**RE: Suncadia P3D18 Short Plat (SP-25-00007) Received Commentary Applicant Responses**

Suncadia Resort LLC respectfully submits this letter in response to the transmittal of combined comments received on Monday, July 21, 2025, for the Suncadia P3D18 Short Plat (SP-25-00007). Below, please find our responses to each of the comments received:

**Kittitas County Public Works – Public Works Plan Review Team**

DWN. BY CAF	DATE 2025-04-17	JOB NO. 998-847-022-0203
CHKD. BY CAF	SCALE 1"=80'	SHEET 2 OF 3

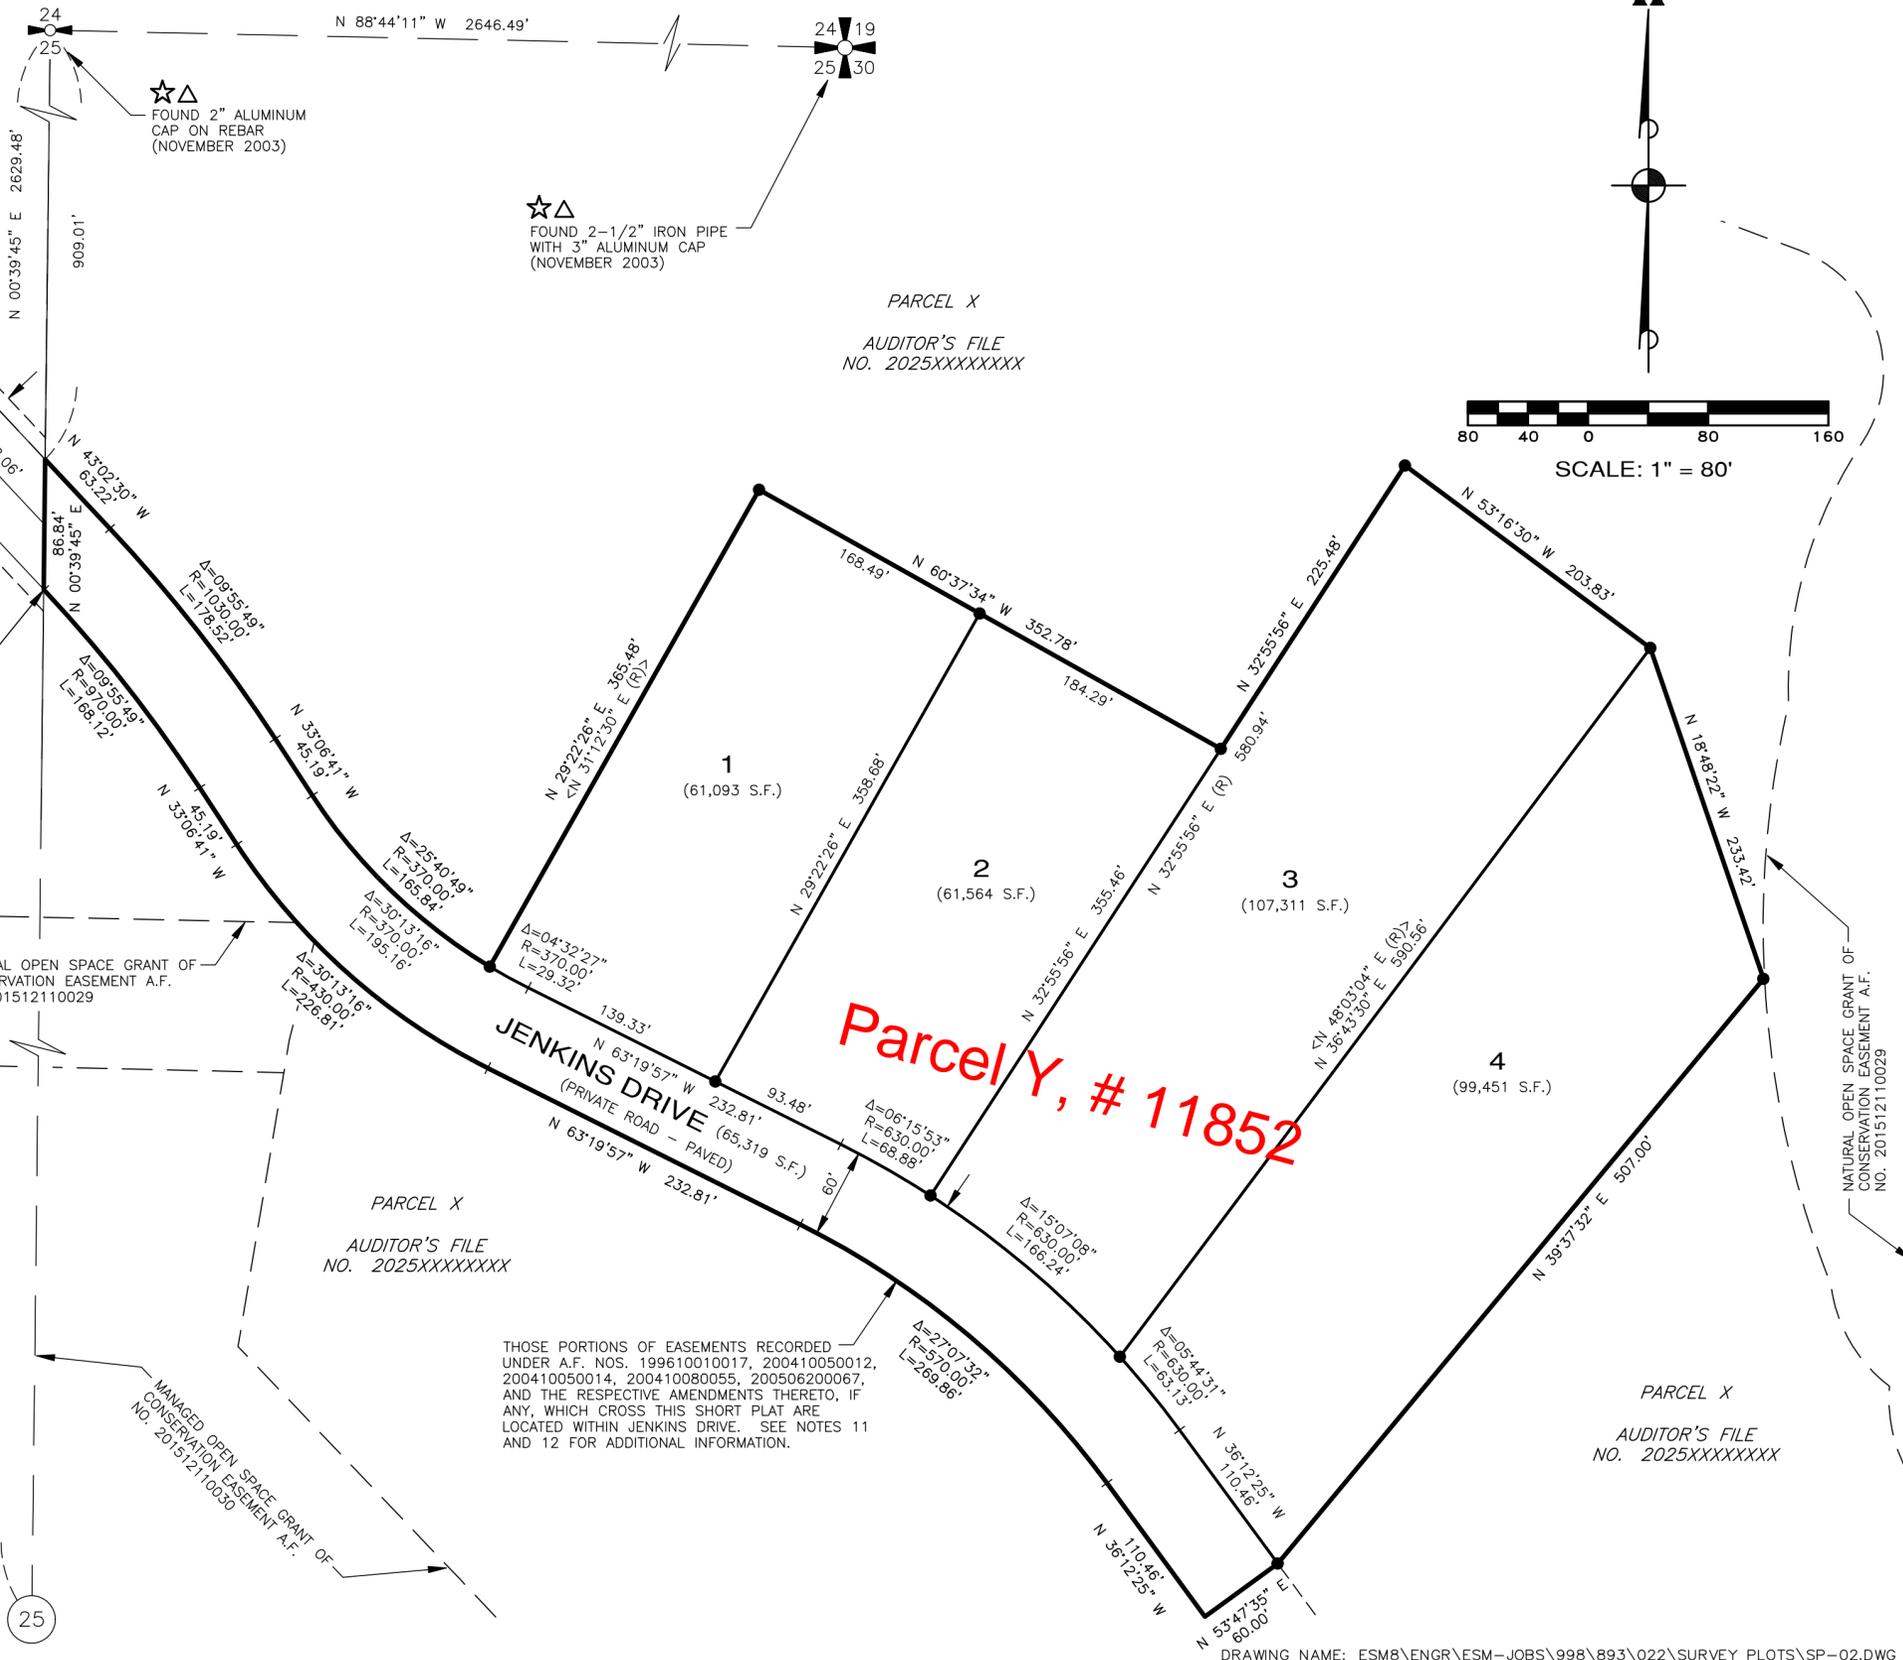
Survey	<p>NOTE: All survey comments are based upon the assumption that the previous record of survey (Application; BL-25-00006) will be filed PRIOR to preliminary approval of this Short Plat application.</p> <p>1. Add set corner symbol to the legend, together with a description of what was set.  <i>Response:</i> The requested symbol and description will be added to the legend.</p> <p>2. Please include Name and Address of Engineer of Record as well as the Date of the Survey (per KCC:16.12.020(5))</p>

<p><u>Response:</u> Note 4 will be added to Sheet 2 stating that Laura Bartenhagen of ESM is the engineer of record. The address for ESM is shown in the title block on each sheet of the short plat. Note 5 will be added to Sheet 2 stating that corners were set in July of 2025.</p> <p>3. Please provide an updated Subdivision Guarantee containing legal description that matches the legal description on the face of the Short Plat. (subject to recording of (BL-25-00006)).</p> <p><u>Response:</u> An updated subdivision guarantee referencing Parcel Y of the recorded BLA will be provided with the re-submittal of the short plat.</p> <p>4. Existing Contours are to be shown, and sufficient data included to meet the requirements of WAC:332-130-145.</p> <p><u>Response:</u> Existing contours will be added in accordance with WAC 332-130-145.</p> <p>5. Please Show "Short Plat" at the top of the page, together with a unique name for the subdivision. (JT)</p> <p><u>Response:</u> The title "Short Plat" and the unique name "Tumble Creek Division 18 Block 1" will be added to the top of the plat sheets.</p>
